**Liddell Battery and Bayswater Ancillary Works Project (SSD-8889679) - Review of Environmental Impact Statement**

BCD have reviewed the Environmental Impact Statement, including relevant appendices, in relation to impacts on biodiversity and flooding.

Legend

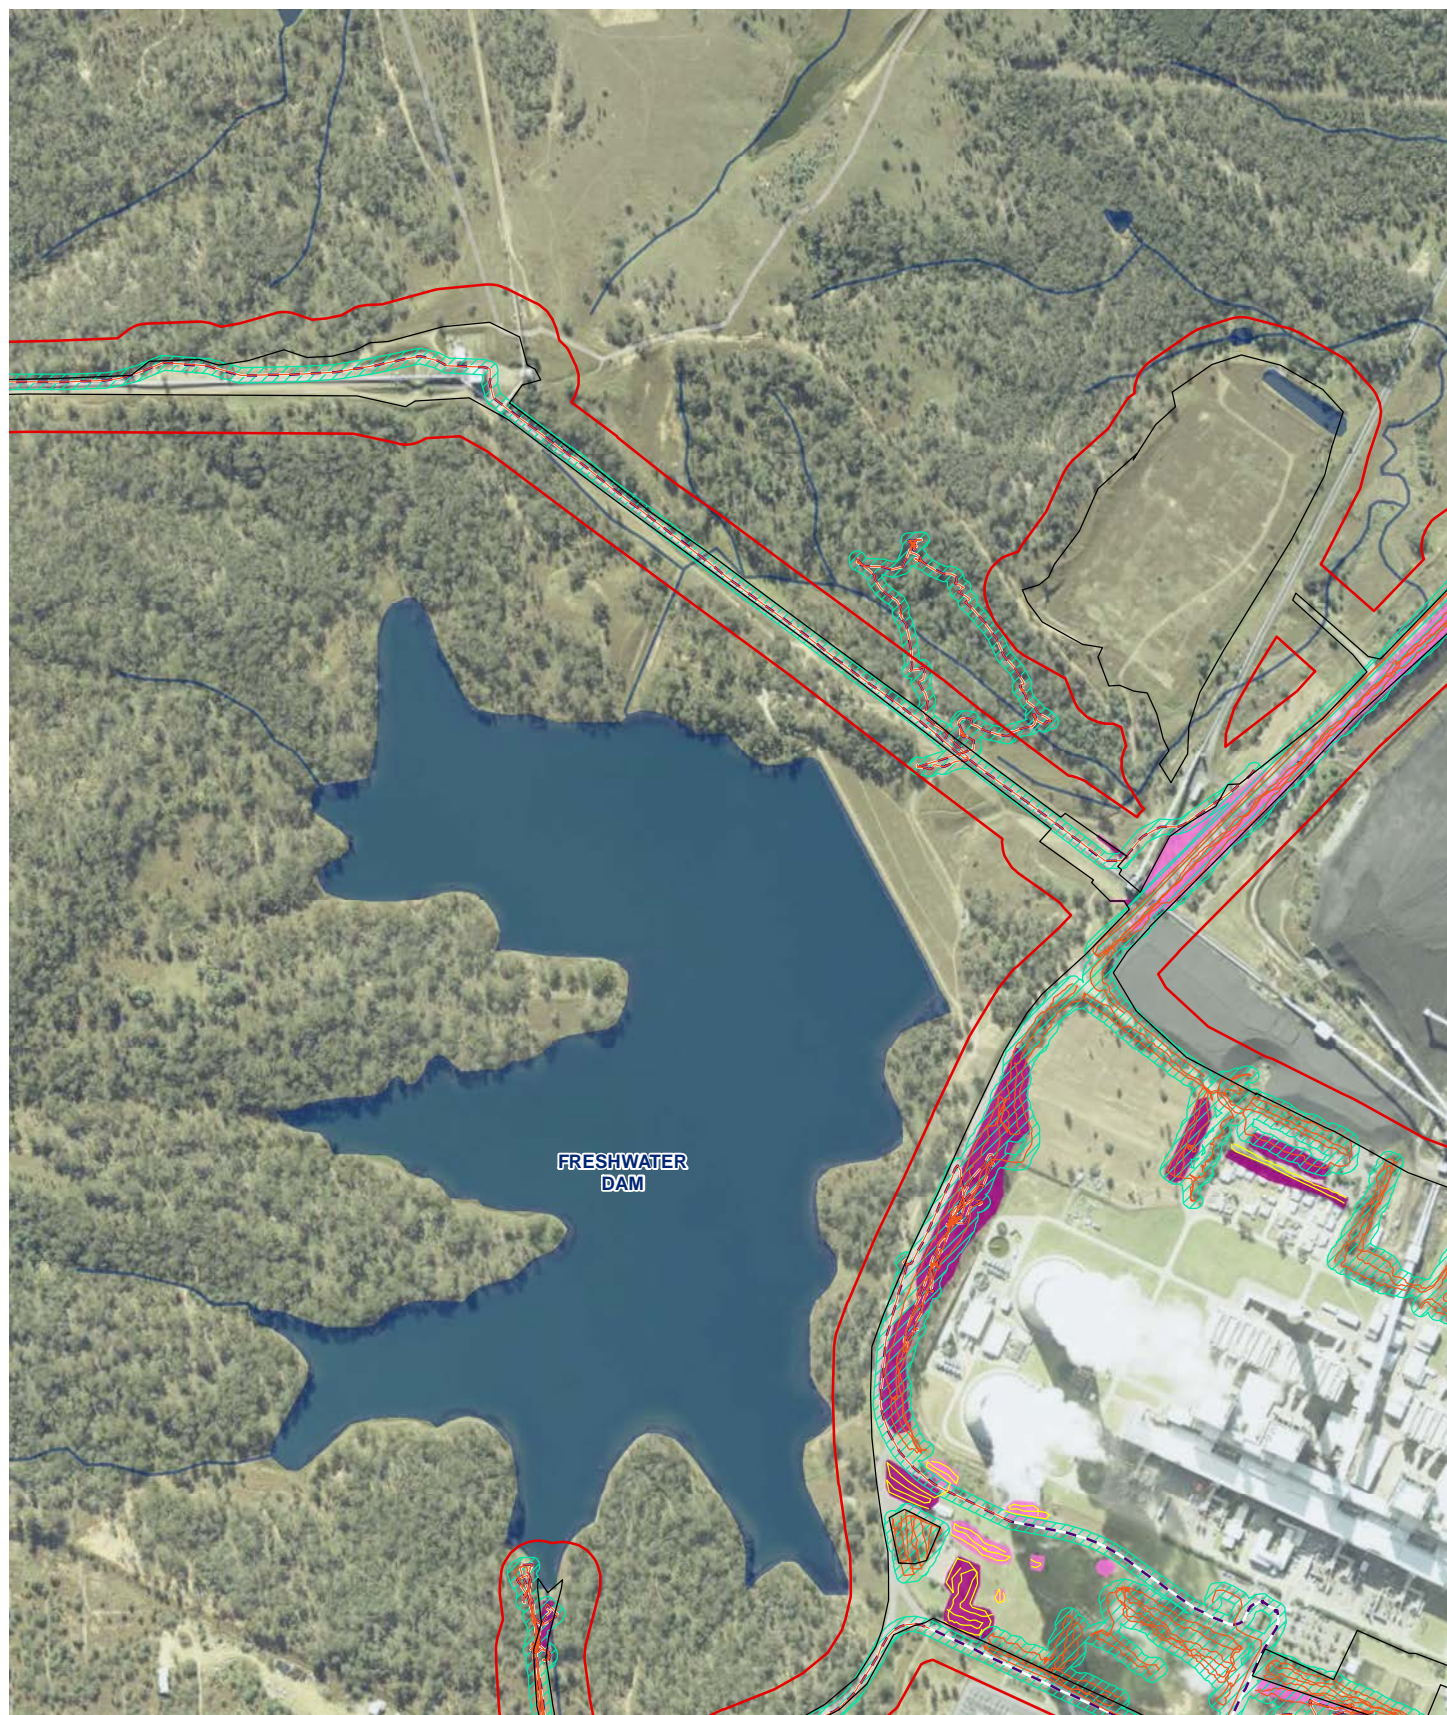
#### 4. Targeted surveys for the threatened plants will need to be shown clearly on revised maps

Section 6.3 of the BDAR describes survey effort for threatened plants, including the threatened ground orchids, *Diuris tricolor* and *Prasophyllum petilum* (syn. *Prasophyllum* species 'Wybong' under the *Environment Protection and Biodiversity Conservation Act 1999*). These orchids were considered not to be present on the development footprint due to targeted survey and Expert Advice from Dr Stephen Bell [Presented as Appendix G: terrestrial Orchid Survey – Expert Advice in the BDAR].

The targeted surveys are described on page 65 as being parallel transects five to ten metres apart in areas deemed to be suitable habitat based on Plant Community Type and vegetation condition (PCT 1691, PCT 1692, derived or modified native grasslands, and rehabilitation areas where exotic grasses were not too dense). The transects are shown on Figure 6-1 (pages 66 to 71 of the BDAR). However, the transects, and the underlying vegetation zones do not show clearly on the figures, which are shown at a scale of 1:25,000. BCD recommends that Figure 6-1 is revised to clearly show the areas where targeted searches were conducted for threatened orchids.

BCD recommends a new version of Figure 6-1 'Threatened flora surveys' is prepared, at 1:1,000 scale, that clearly shows the location of targeted flora surveys, and the vegetation zones in which they were conducted.
